RE: Objection to proposed development of 11-23 Rangers Avenue Mosman (SSD-96272465)

1.1. This submission is prepared by the owner of 28 Holt Avenue, in response to the proposed development of 11-23 Rangers Avenue (SSD-96272465) by Grand Noble Project 1 Pty Ltd (the Applicant). Our home is immediately to the north of the proposed development site. We object to the proposed development on the following ground:

Figure 3 Public transport services

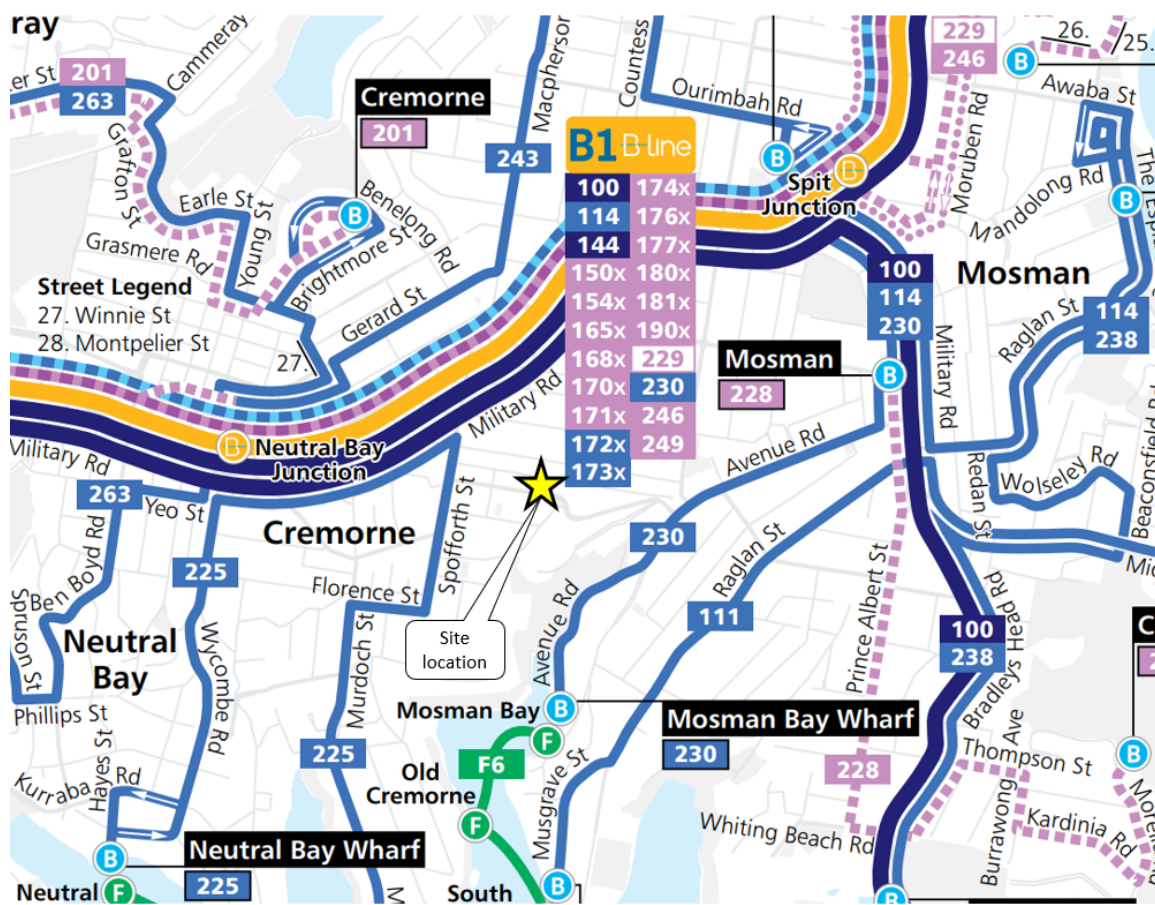
- (d) Figure 3 shows only one bus route travelling along Spofforth St. However, it omits the following routes: 560N, 565N, 566N, 708N, 762N, 792. In addition, there is a bus stop on Spofforth Street just before the intersection with Holt Avenue. This makes crossing even more difficult, as it reduces visibility when buses have stopped at the bus stop.

Figure 9 Crash data

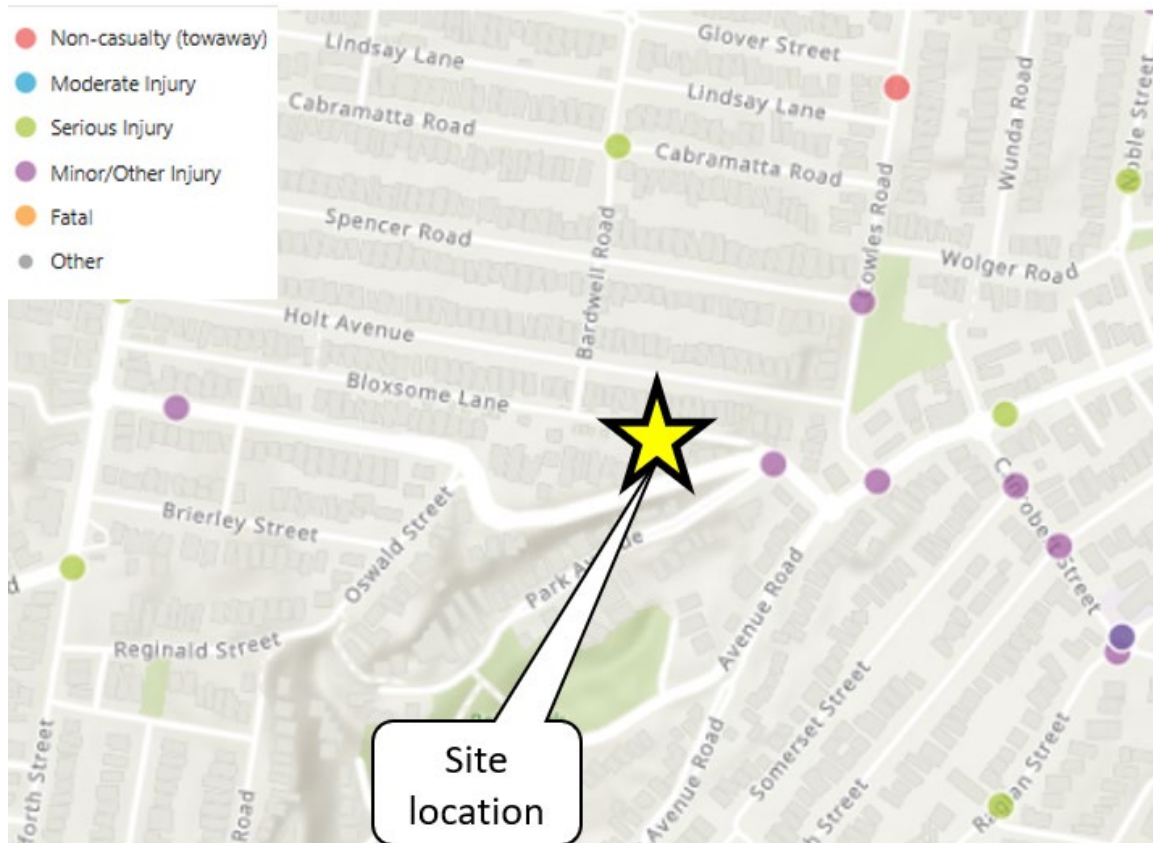
- 2.11. This can be compared with Spofforth Street.
 - (a) Figure 9 shows Spofforth Street has had a “serious injury” in the last five years at the very point that the surveyor has proposed to cross. We note that the key to the map almost entirely covers up the fact that there was a “serious injury” at the intersection of Holt Avenue and Spofforth Street.
